Our Ref: F/13/19/PL

**Town & Country Planning Act 1990 (as amended)
Town and Country Planning (Development Management Procedure) (England) Order 2015
Application for Planning Permission**

Development New workshop building and redevelopment of existing building and site with new portal frame structure above existing building footprint

Location Ford Lane Business Park Ford Lane, Ford,

PROPOSED FLOOR PLANS PHASE 1

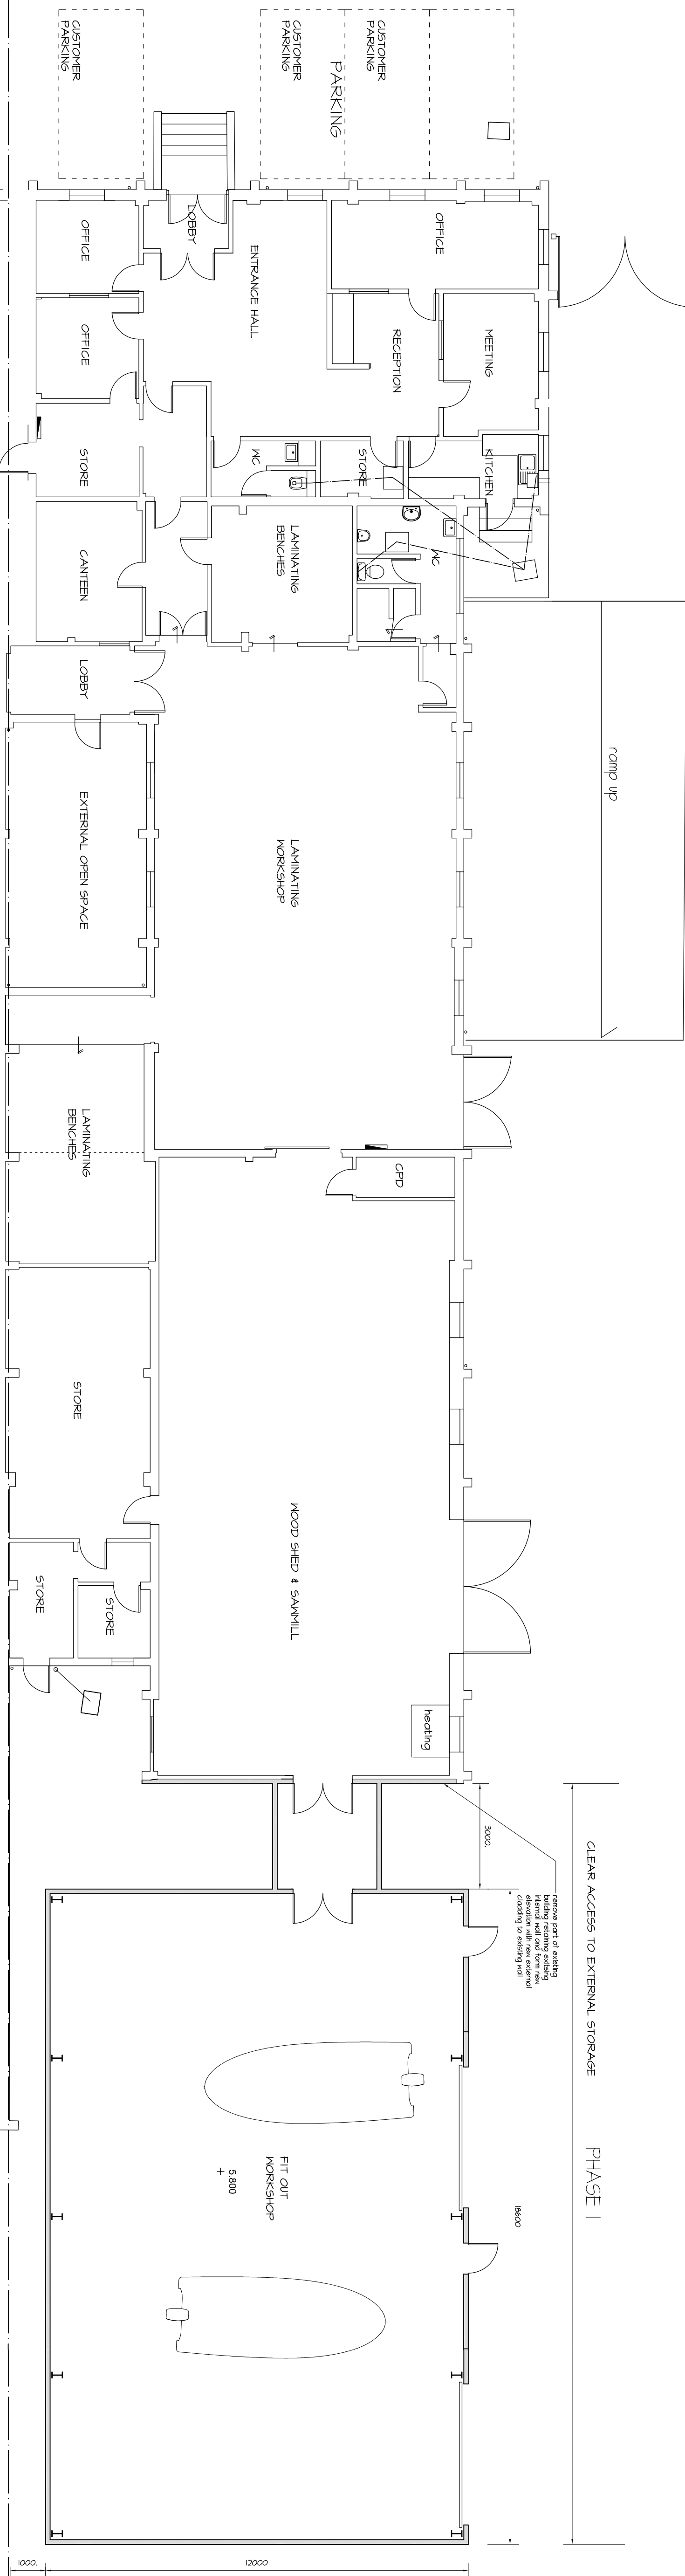
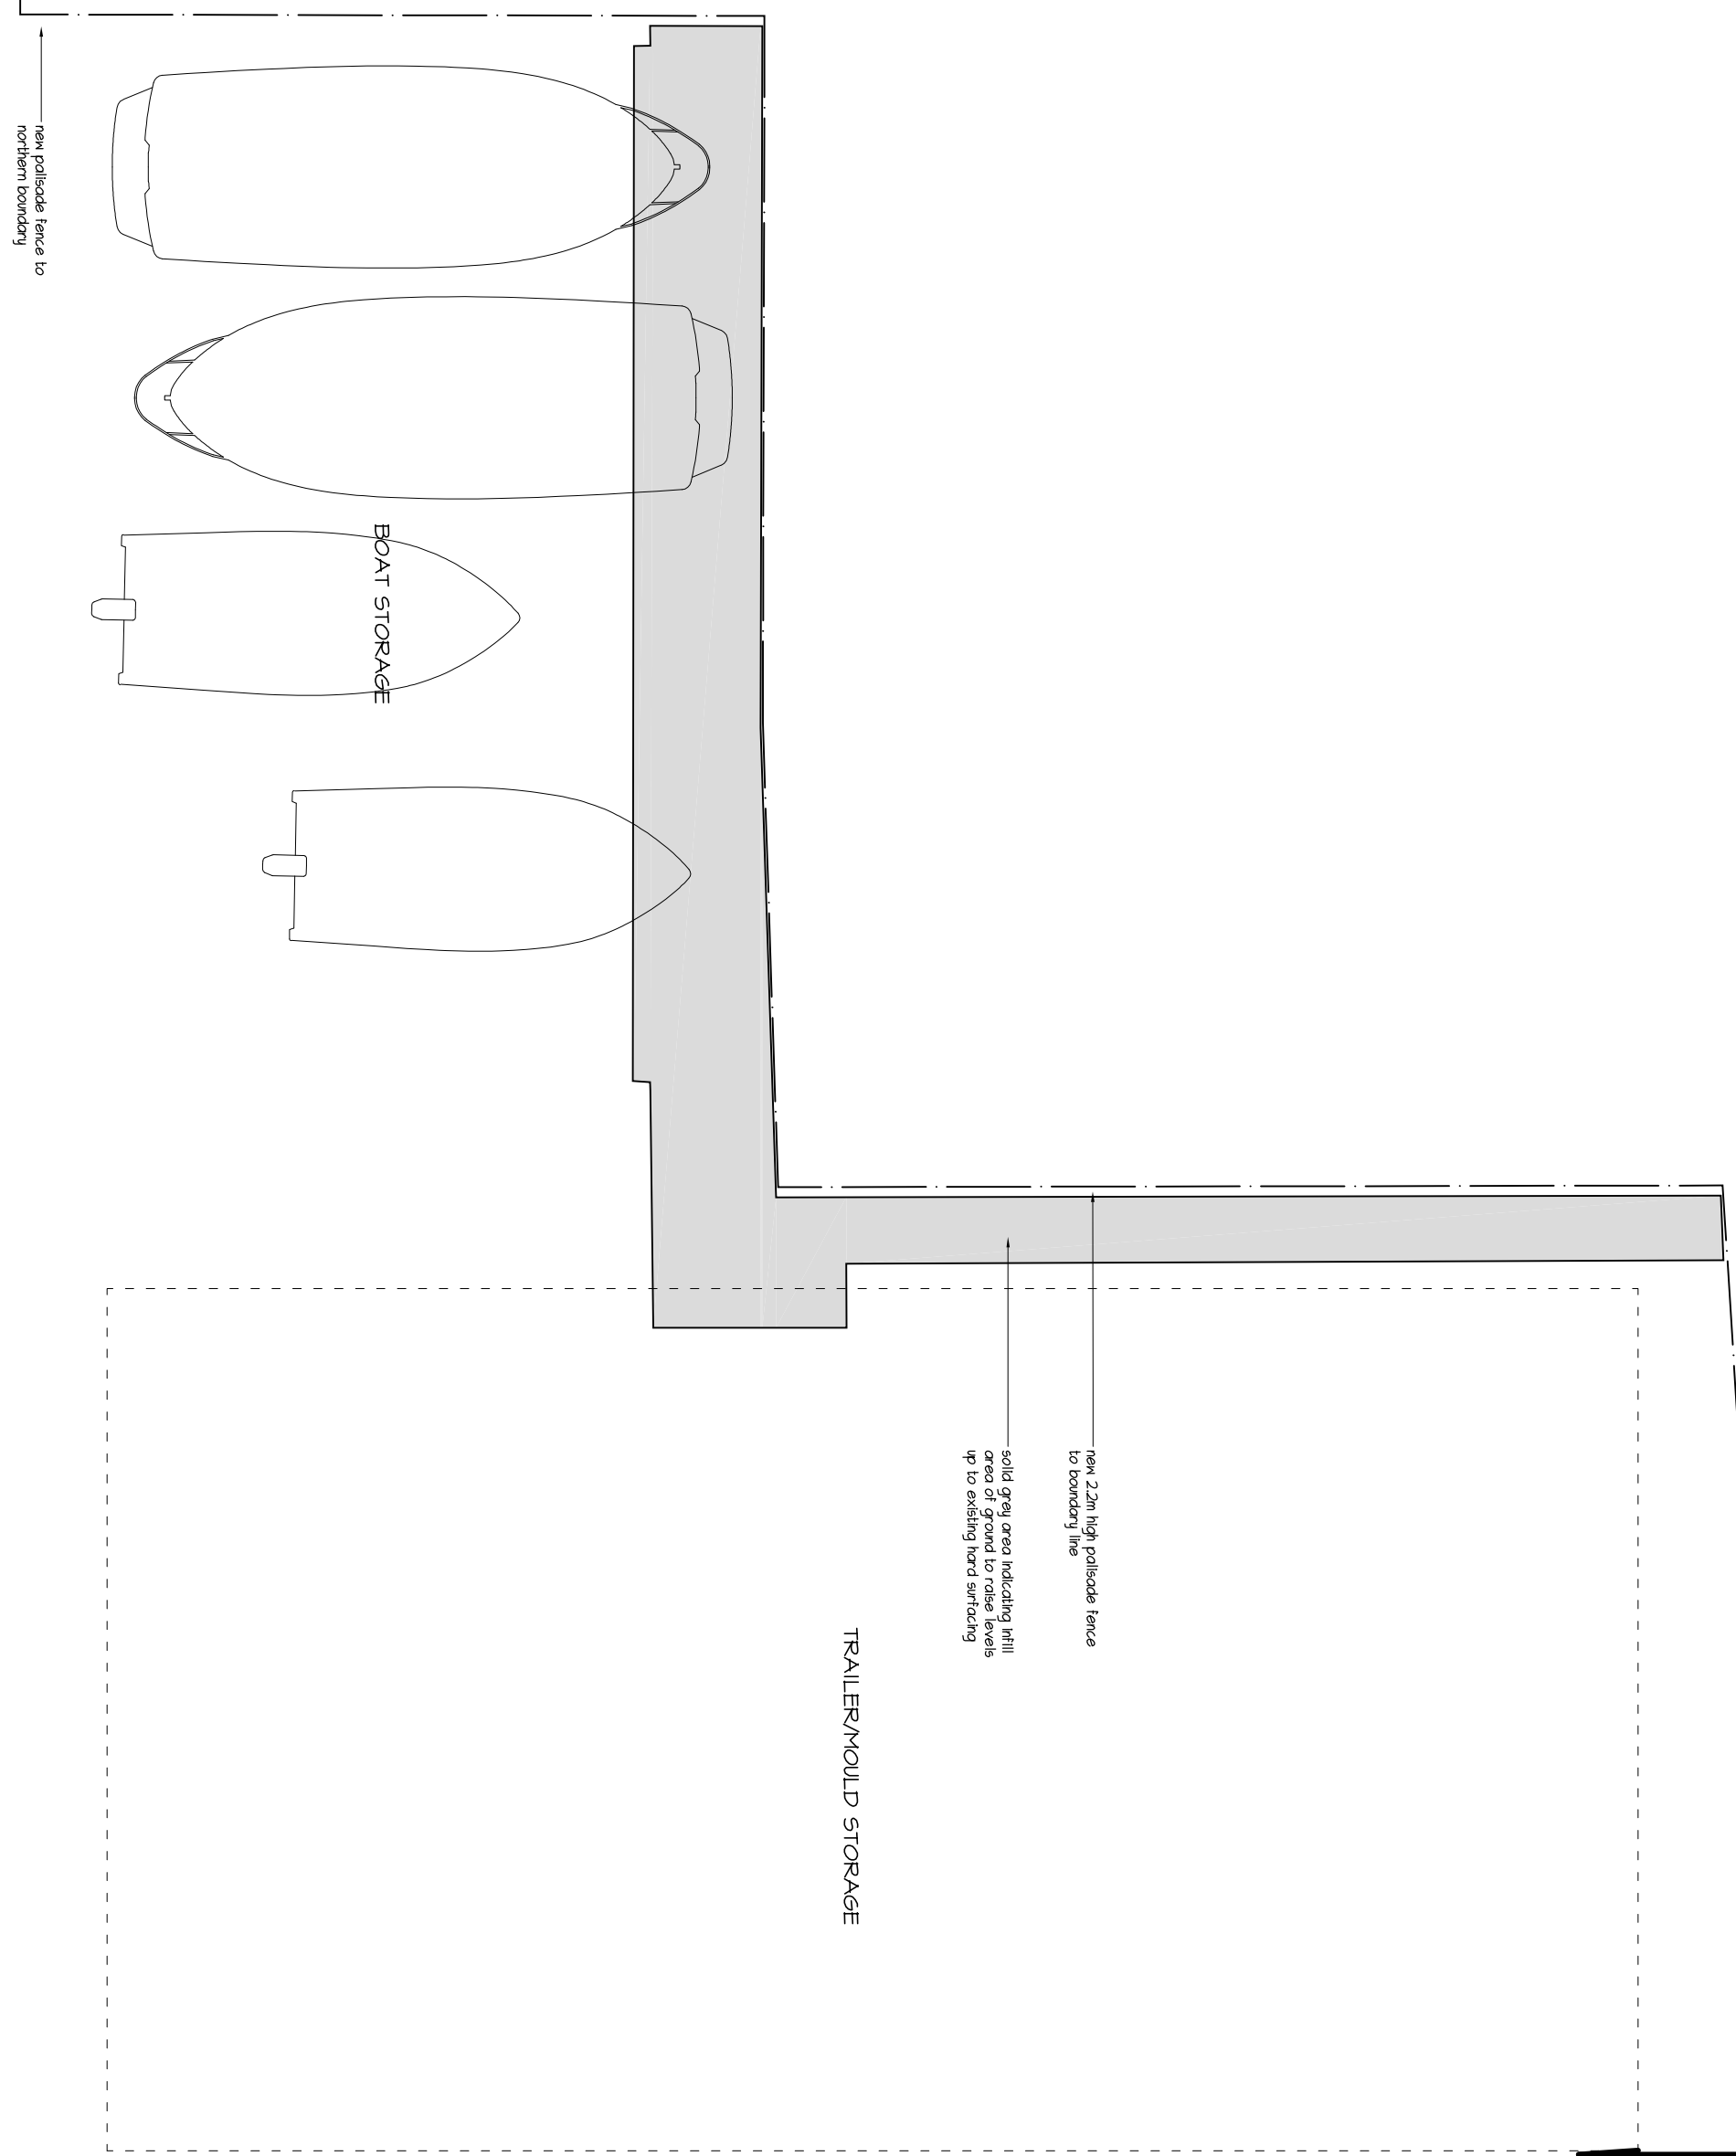
Woodshed & Sawmill - The floor plans are omitting the GF door & FF windows. Please forward amended plans accordingly.
